Drax Biomass Immingham Limited

Planning Inspectorate Reference:TR030001

Drax Biomass Immingham Limited (DBIL) has been registered as an interested party with respect to the DCO application submitted by Able Humber Ports Limited (Able) for the development of the Marine Energy Park (MEP). DBIL has consent under Section 36 of the Electricity Act 1989 and an Environmental Permit for the construction and operation of a 299MW biomass fuelled power station (Heron Renewable Energy Plant to Heron REP) on land adjacent to the Port of Immingham and to the South of the proposed MEP. Having reviewed the documentation submitted by Able, it is evident that, without binding requirements/conditions being imposed, the proposed MEP has the potential to impact adversely on the proposed Heron REP.

Scale:	Drawn By	Checked By	Approved By
1:50,000@A3	R Keir	R Cram	R Cram
Date:	21/09/2010	21/09/2010	21/09/2010
Drawing No.	Revision:		E
AME - 02001

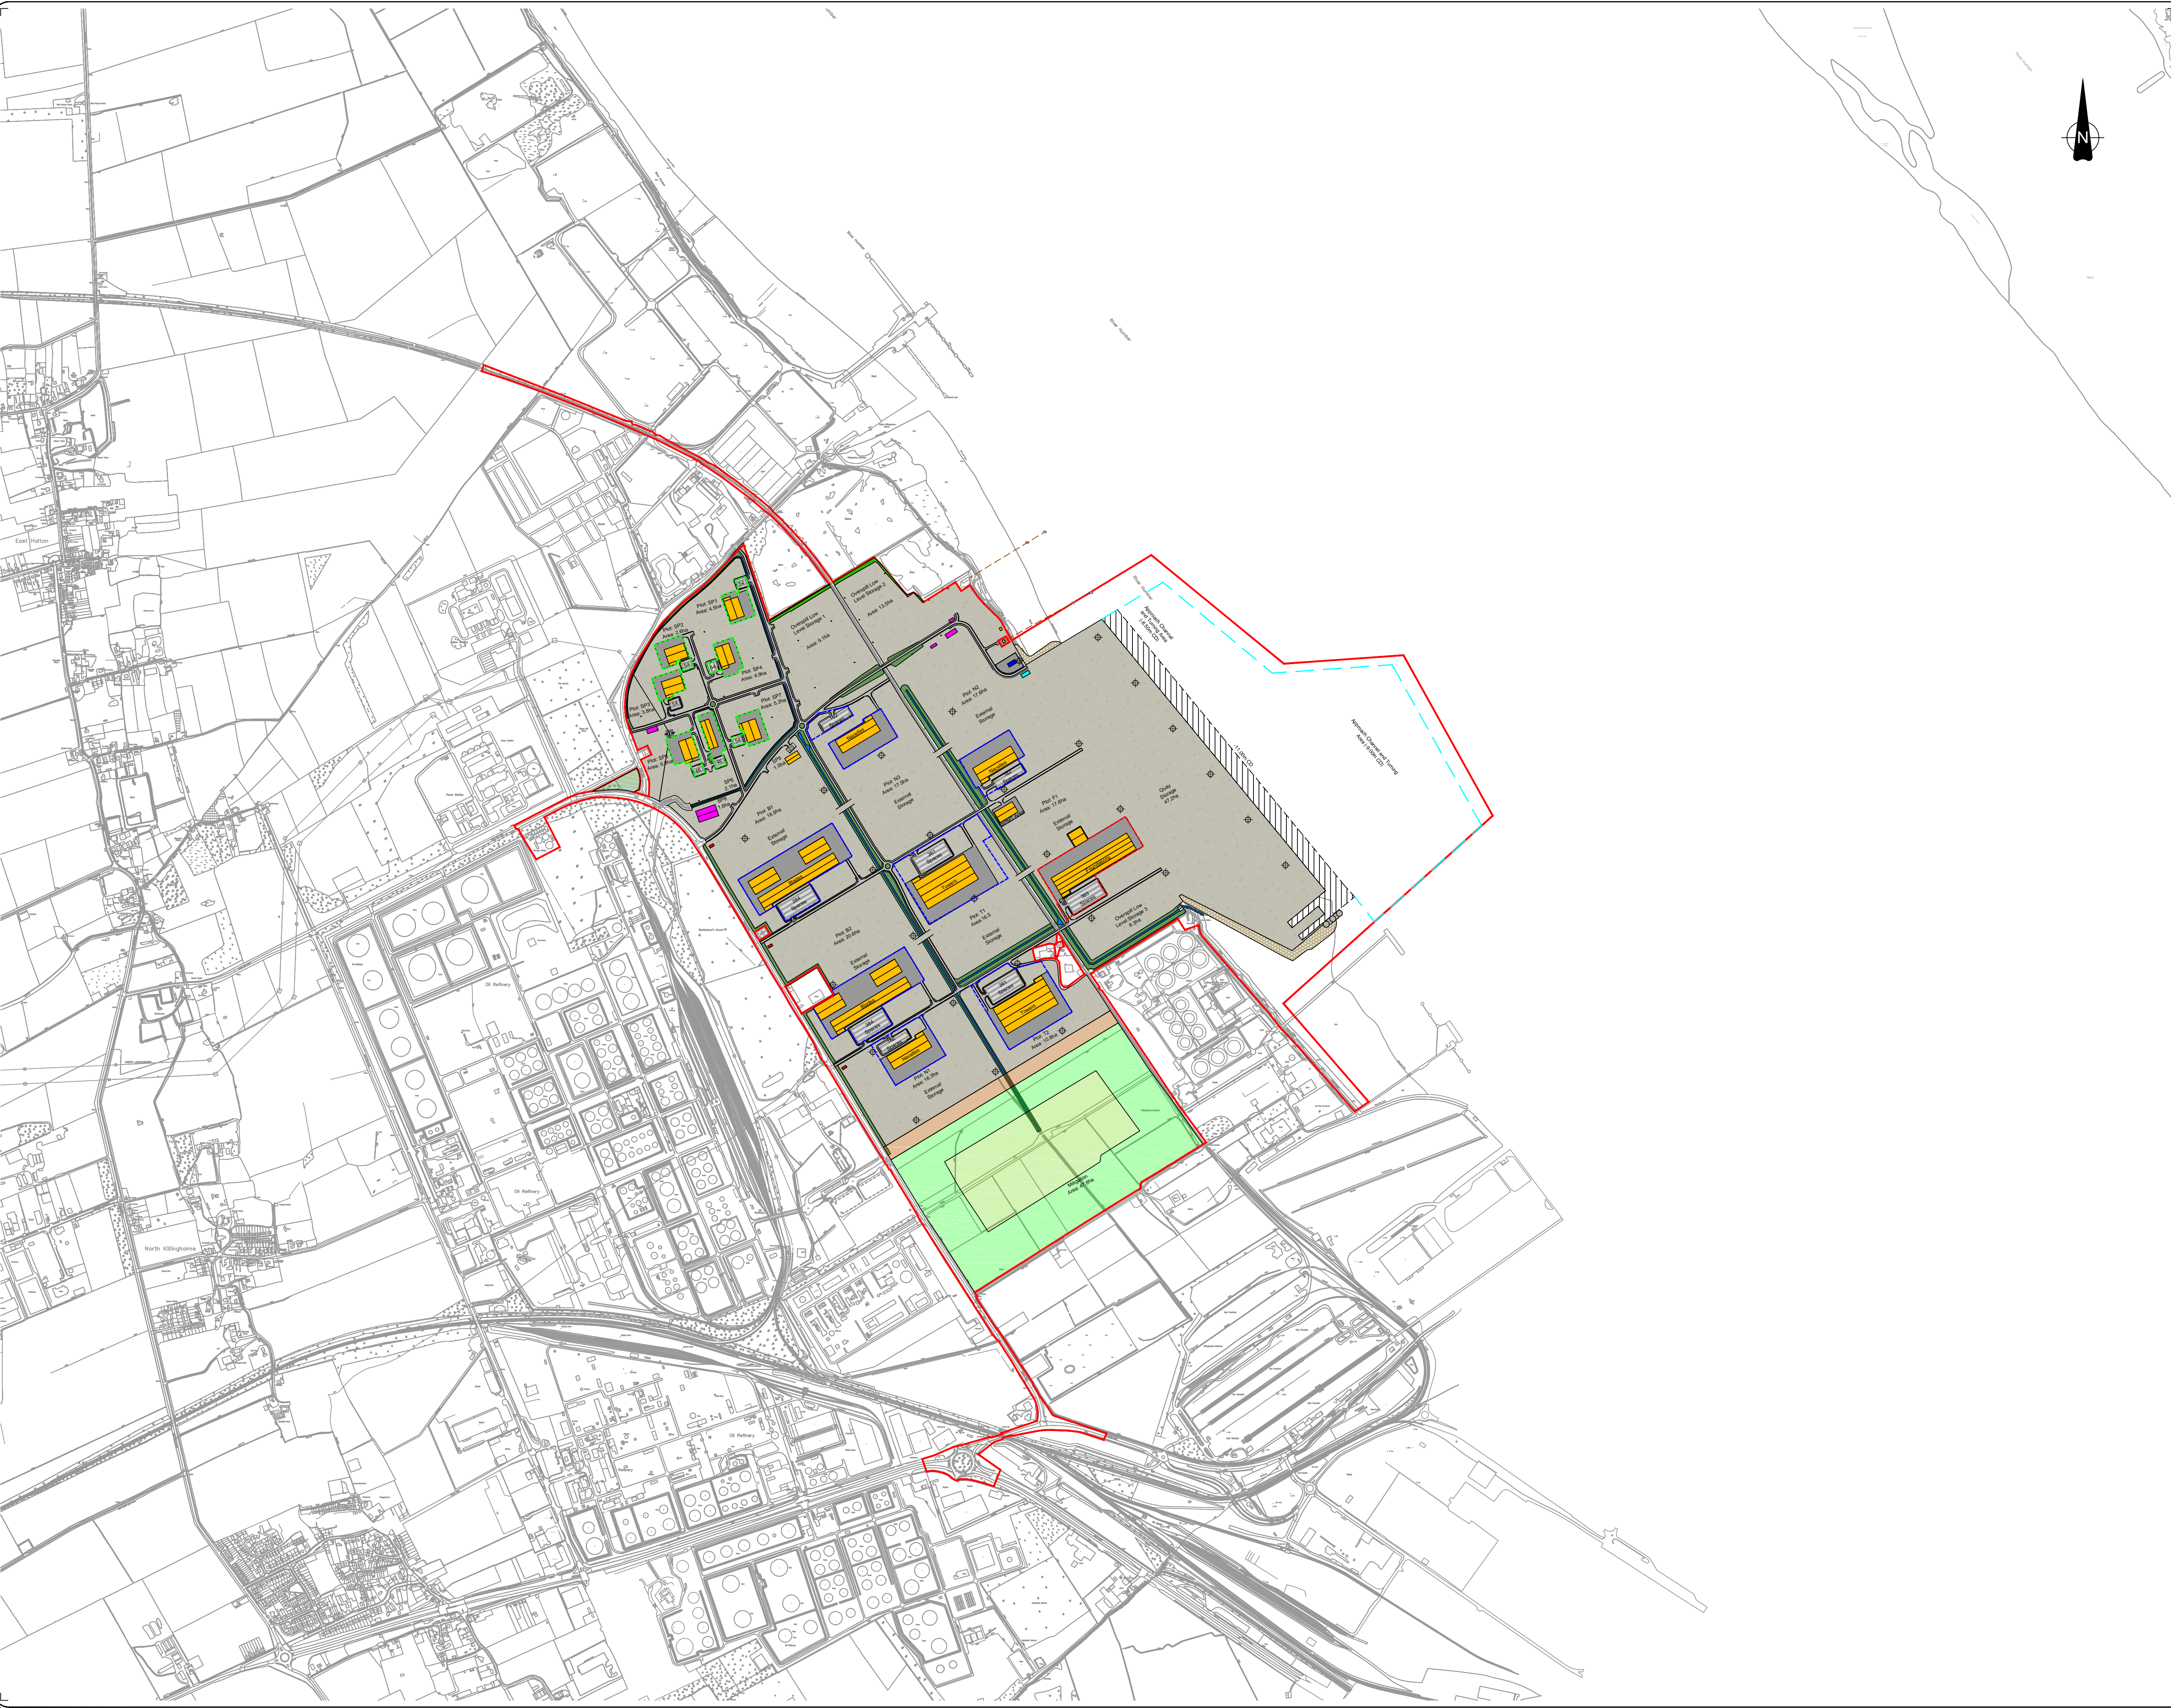
The DCO application which Able have submitted for the MEP includes land over which DBIL holds an option to lease land for laydown areas during construction of the REP. [The Site Location Plan](#) (Drawing Number AME02000) shows the land which Able UK has identified for the development of the MEP; Figure 1.2, Volume 3 of the Environmental Statement shows the area indicated for laydown. Other issues such as DBIL's access to specific areas of land during construction and operation of the Heron REP as well as the impacts of the MEP development on Rosper Road, Marsh Lane and Humber Road must be clearly understood and considered. DBIL are in discussion with Able and are seeking resolution on these issues. However, until resolution is forthcoming, DBIL must object to the Compulsory Purchase of the specific areas of land for which DBIL has options for lease as well as the Compulsory Purchase of Rosper Road.

DBIL has had discussions with Anglian Water regarding the supply of potable water to the Heron REP. Anglian Water indicated that they would investigate the capability of connecting the Heron REP site to a potable water supply. When referring to the Site Location Plan, it appears that infrastructure associated with Anglian Water's assets have been included within the area covered by the DCO application. It would be beneficial to understand whether Able believe that there will be an impact on Anglian Water's assets. In addition, DBIL had also discussed the possibility of connecting into the existing sewerage system owned and operated by Anglian Water. Again, it would be beneficial to understand whether there is any potential impact on the ability of Anglian Water to provide services to treat domestic wastewaters.
